**Transport
for NSW**

**Site 68 Mixed Use Development, Sydney Olympic Park (SSD 6603)
Notice of Exhibition**

Attachment 1 Transport for NSW Comments

PROPOSED SITE 68 - ACCESS DIAGRAM

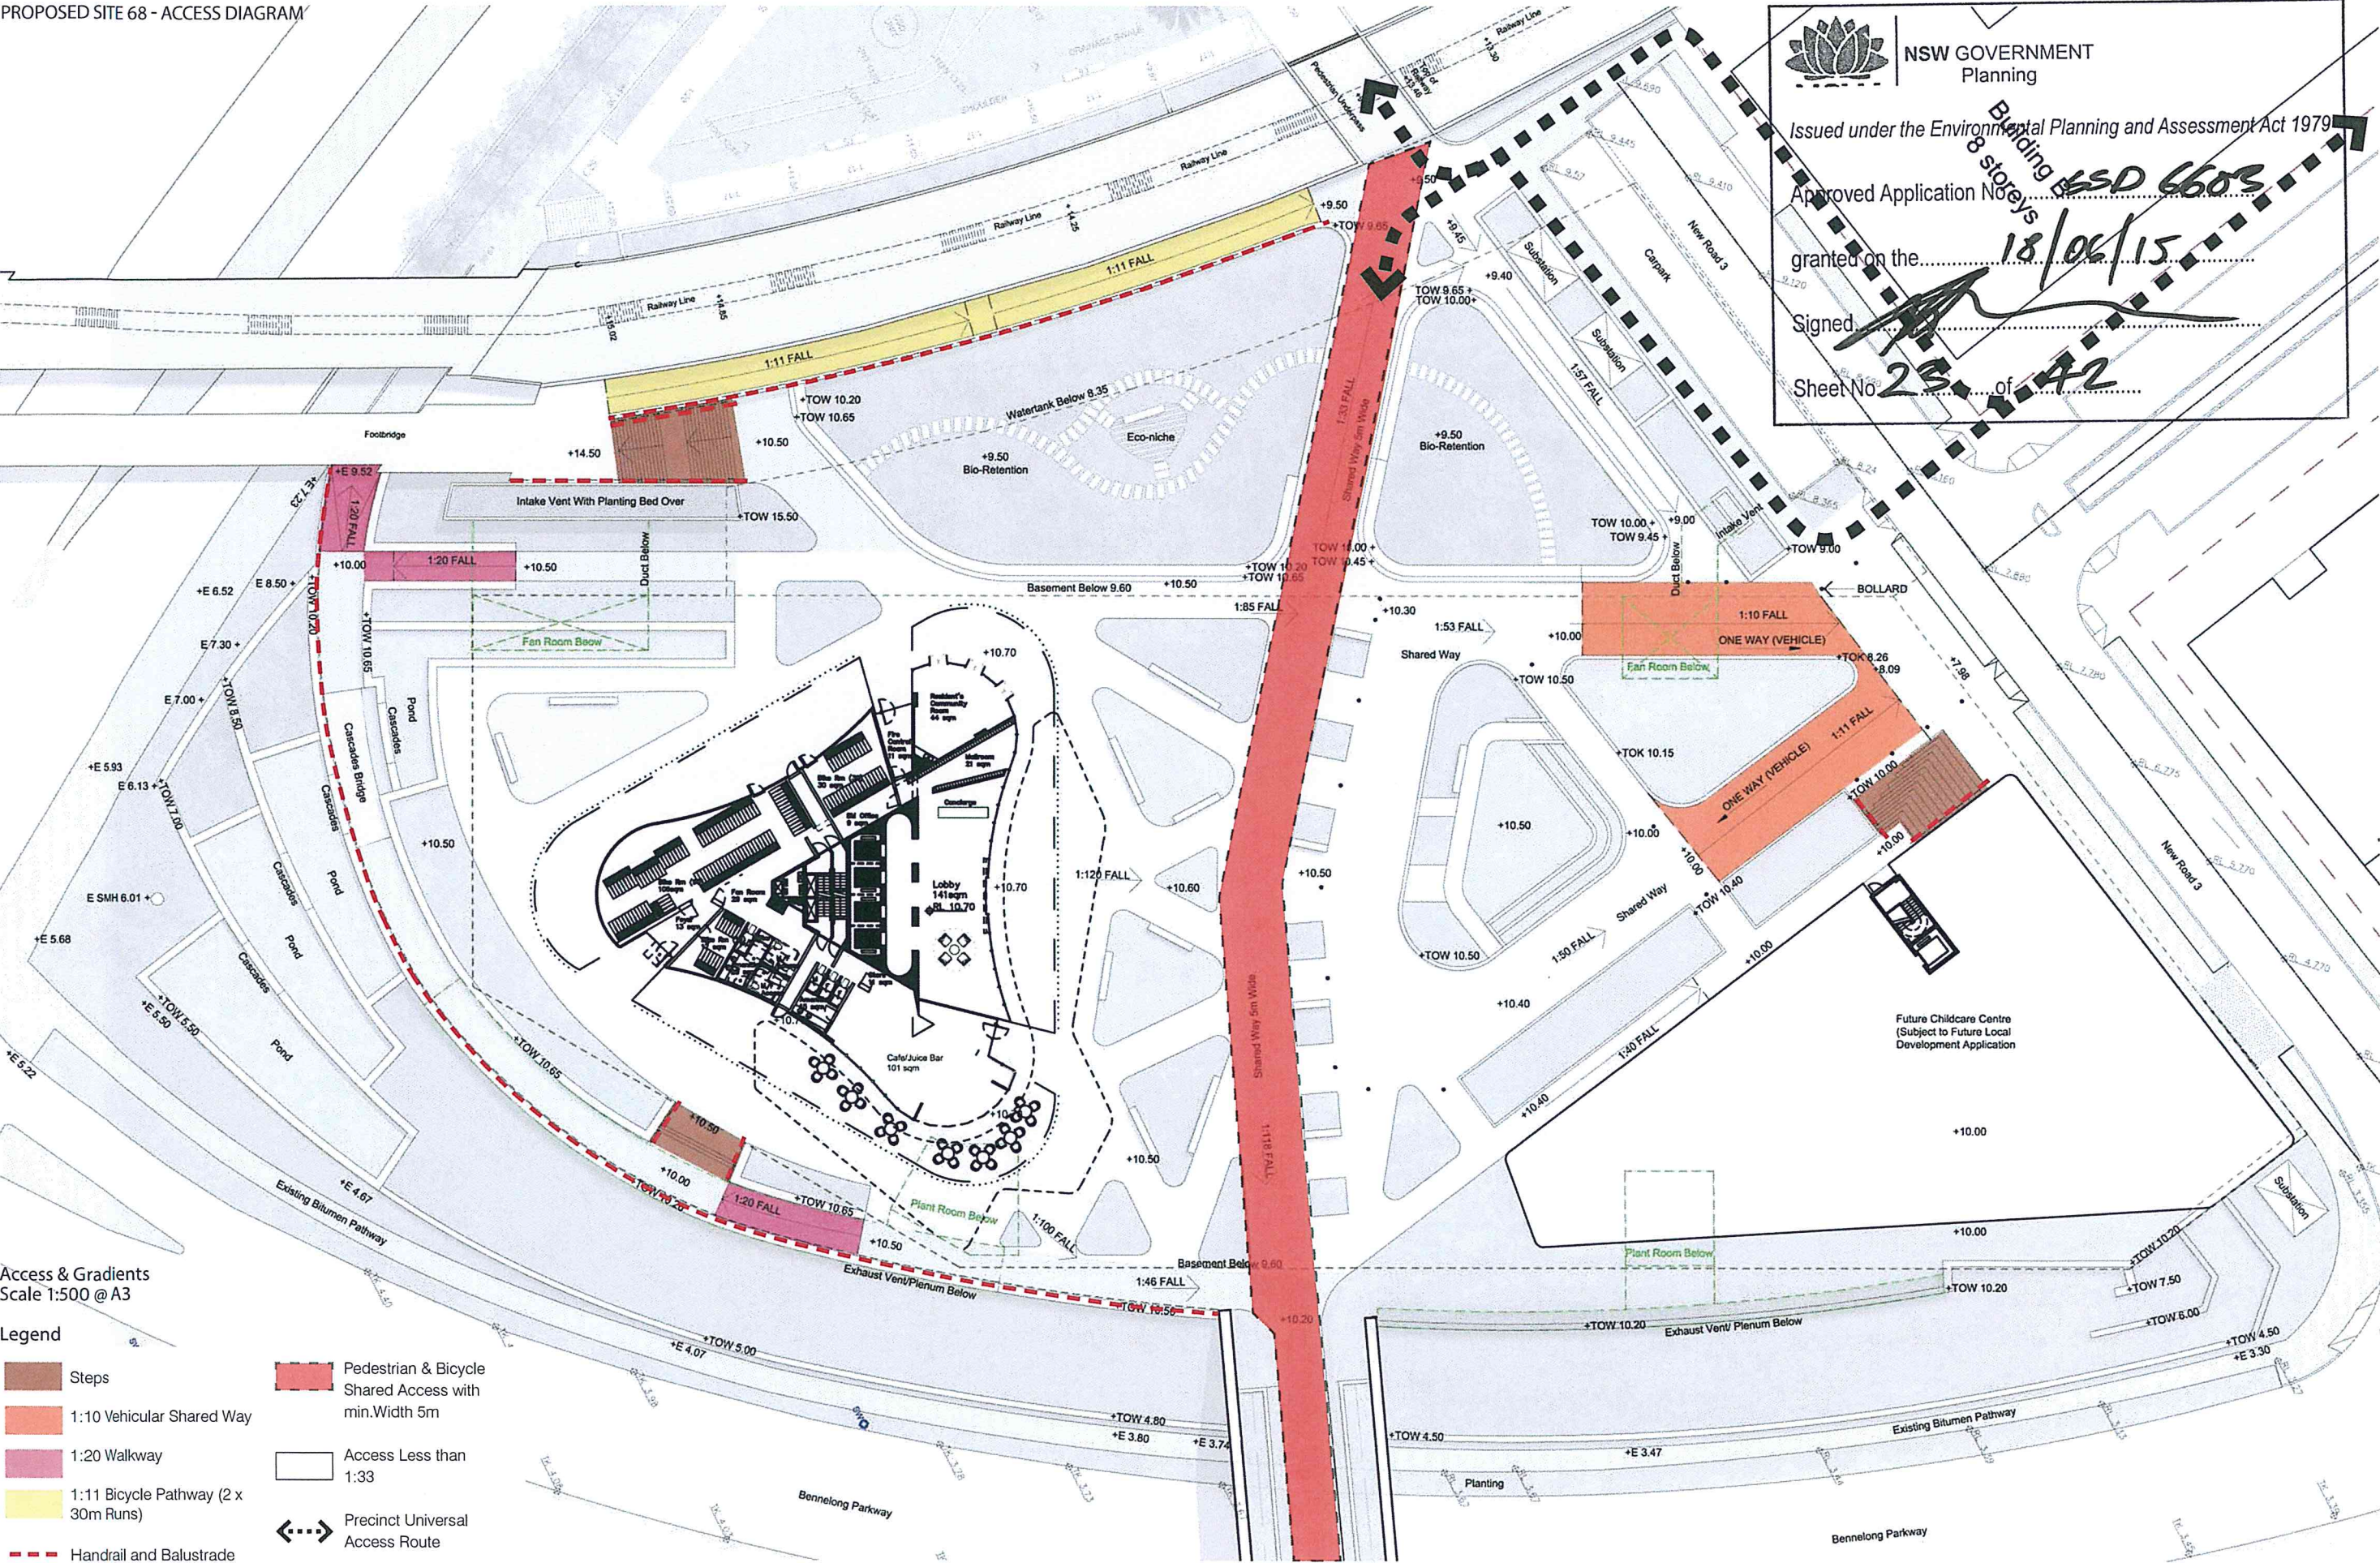
- Under Section 4: Design Considerations, it is noted in section 4.3, Sight triangles, that the current design does not have the required sight triangle on the western side of the driveway.

- The development is to provide an approved sight triangle device on the western side of the drive to alert pedestrians to the presence of cars.
- Prepare a Construction Traffic Management Plan (CTMP), which details construction vehicle routes, number of trucks, hours of operation, access arrangements and traffic control. The plan should also specify any potential impacts to bus services operating on roads within the vicinity of the proposal site from construction vehicles during construction. Any potential impacts to pedestrian access or public transport infrastructure including train and bus stops are to be specified. Should any impacts be identified, the duration of the impacts and the measures proposed to mitigate these, including any temporary relocation of services, are to be clearly explained and committed to being enforced. The CTMP should be submitted to the Department of Planning & Environment for review prior to the issue of a Construction Certificate.
